Recommendation Report for Planning Permission for Works or Extension to a Dwelling

REF NO: P/18/21/HH

LOCATION: 1 Church Close
Pagham
PO21 4NT

PROPOSAL: Two storey side extension with front and rear single storey extensions

PROJECT	1 Church Close	DATE	01/02/21
TITLE	Proposed Plans	DRG NO	IBA/545/03
SCALE	1 : 100	REVISIONS

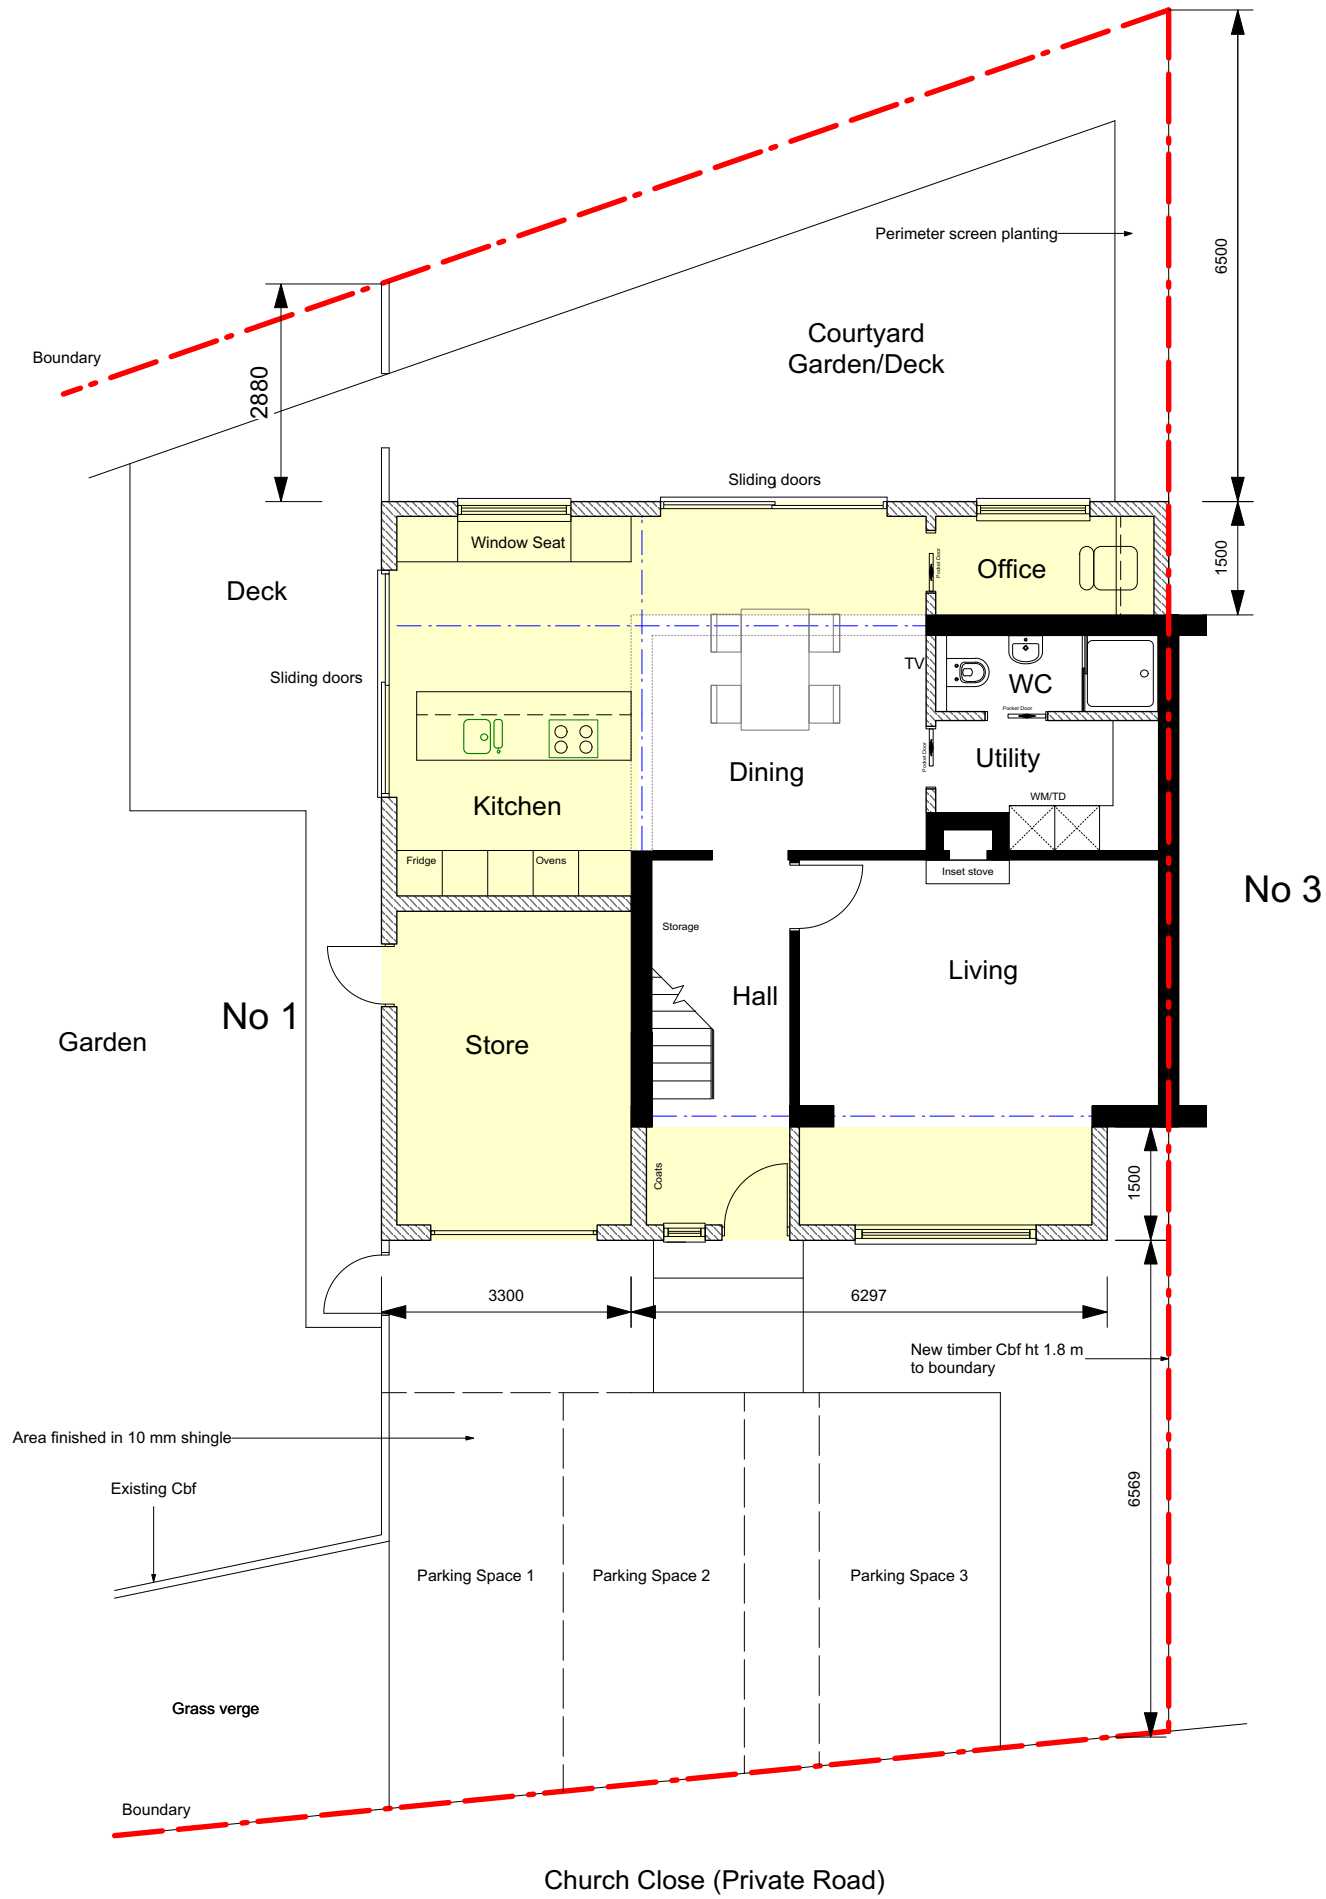
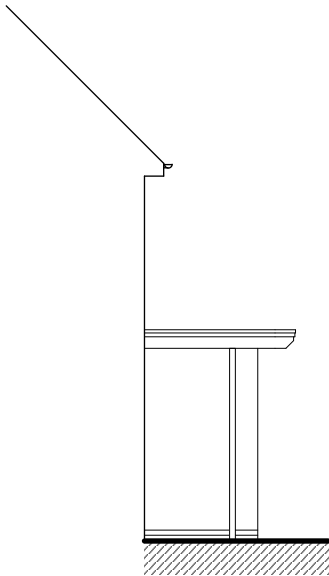
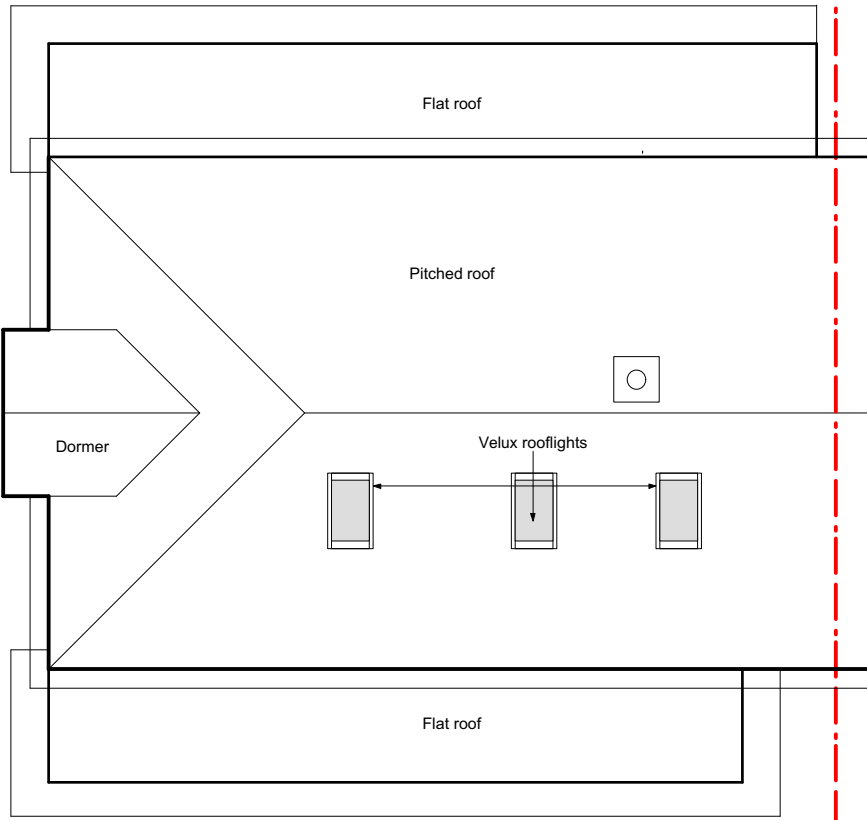
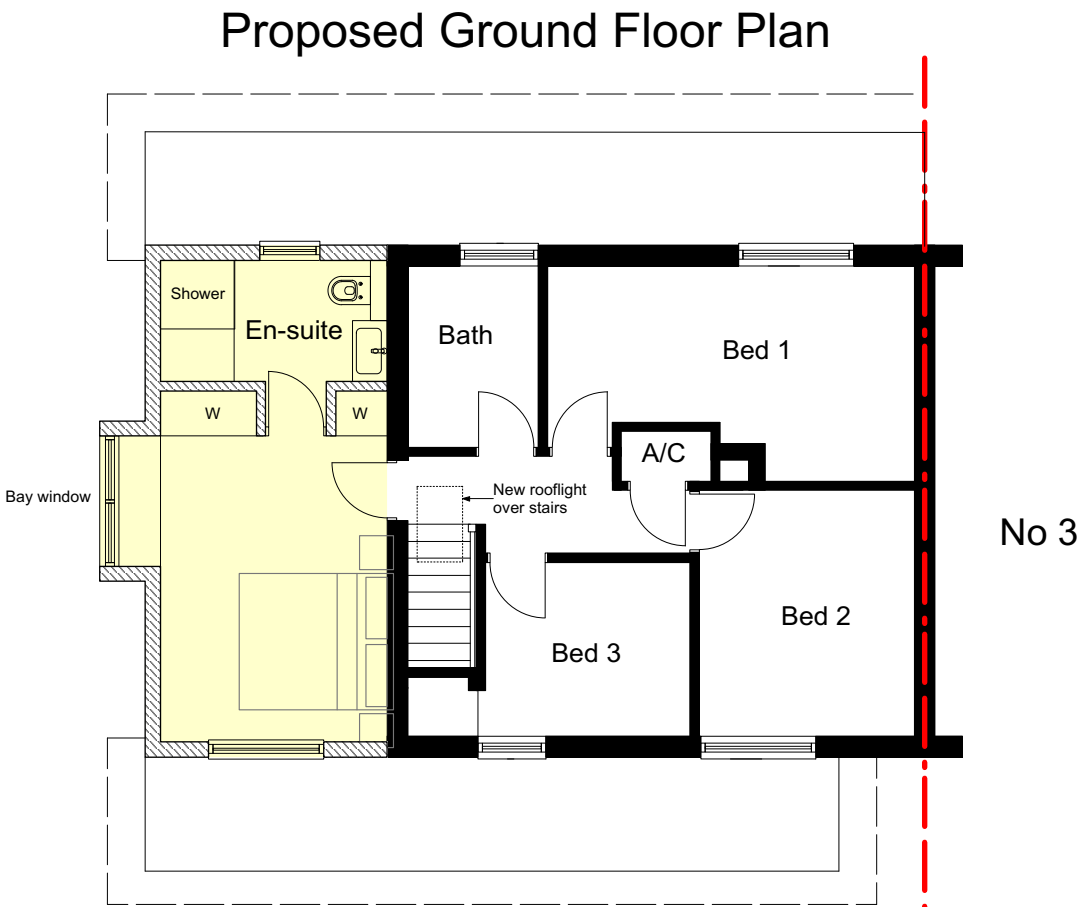
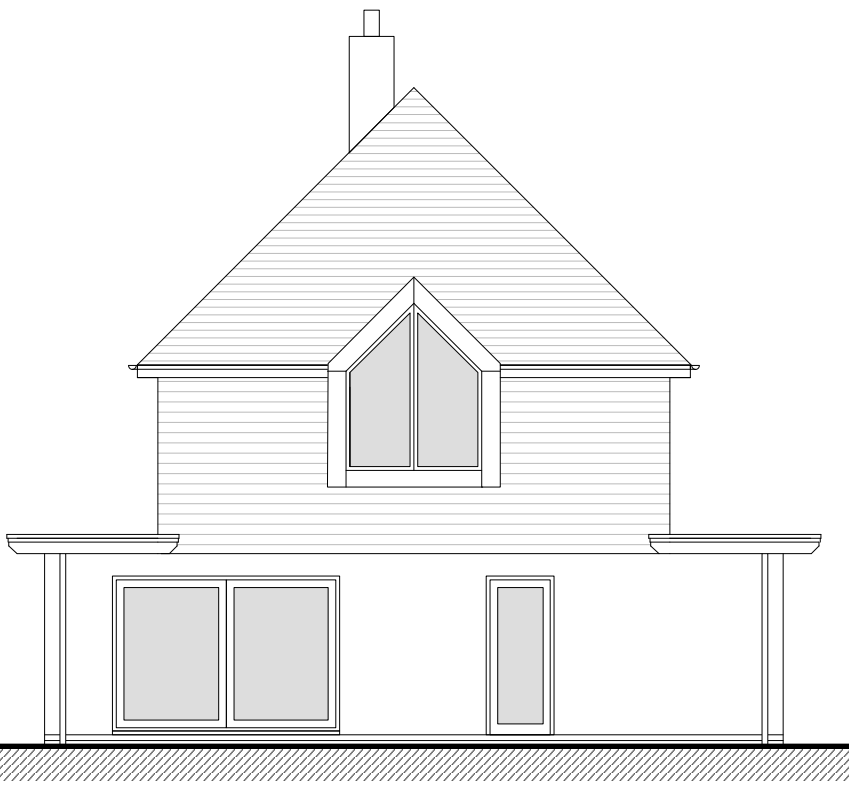
There will be a porch to the principle elevation with a width of 6.297m. This will connect to the side extension which will have a width of 3.3m. It will have a depth of 1.5m however retains 6.569m to the front boundary.

The porch will have a flat roof at a height of host dwelling. This extends beyond that of the neighbouring property however it is well integrated and not considered to appear unduly dominant upon the front elevation of the property. Additionally, there is a gap between the edge of the porch and the boundary allowing the proposal to not dominate the front elevation or overbear the neighbouring property.

A two storey side extension will be constructed with a width of 3.3m. This is well integrated appearing sympathetic in appearance to the design of host dwelling meeting with the ridge height. The use of materials is acceptable. There is sufficient space retained to the side elevation of the dwelling in such that it does not appear as an overdevelopment on the site with the majority of the amenity space for the property to the side.

The rear extension will be 1.5m in depth and have a width of 10m to meet the side extension forming a full width extension to the rear of the property. This will have a flat roof, due to the neighbouring property having a large rear extension this is not considered to be harmful to the character of the area.

The side extension is situated to the north elevation and runs along the full side with a width of 3.3m, meeting in line with the rear building line. This retains 5.5m to the southern boundary however there are no neighbouring properties to this side. 5m is retained to the rear boundary which increases as the garden extends to the north.

There will be 2 additional windows and a pair of doors to the east elevation, due to the location at ground floor level with views over the garden, it is not considered to provide adverse overlooking. To the first floor there is 1 bay window overlooking the main amenity space to the north. There will also be the addition of roof lights to the roof on the western side facing the street scene, along with ground floor windows that will also overlook the street scene. The first floor bathroom window will also be controlled to prevent overlooking.

The potential for overlooking would come from the flat roofs of the extensions, as such it has been conditioned that there will be no use of the roofs as balconies.

Reason: To safeguard the amenities of the occupiers of adjoining property in accordance with policy D DM1 of the Arun District Local Plan.
- 4 The first floor en-suite window on the east elevation of the building shall at all times/be glazed with obscured glass.
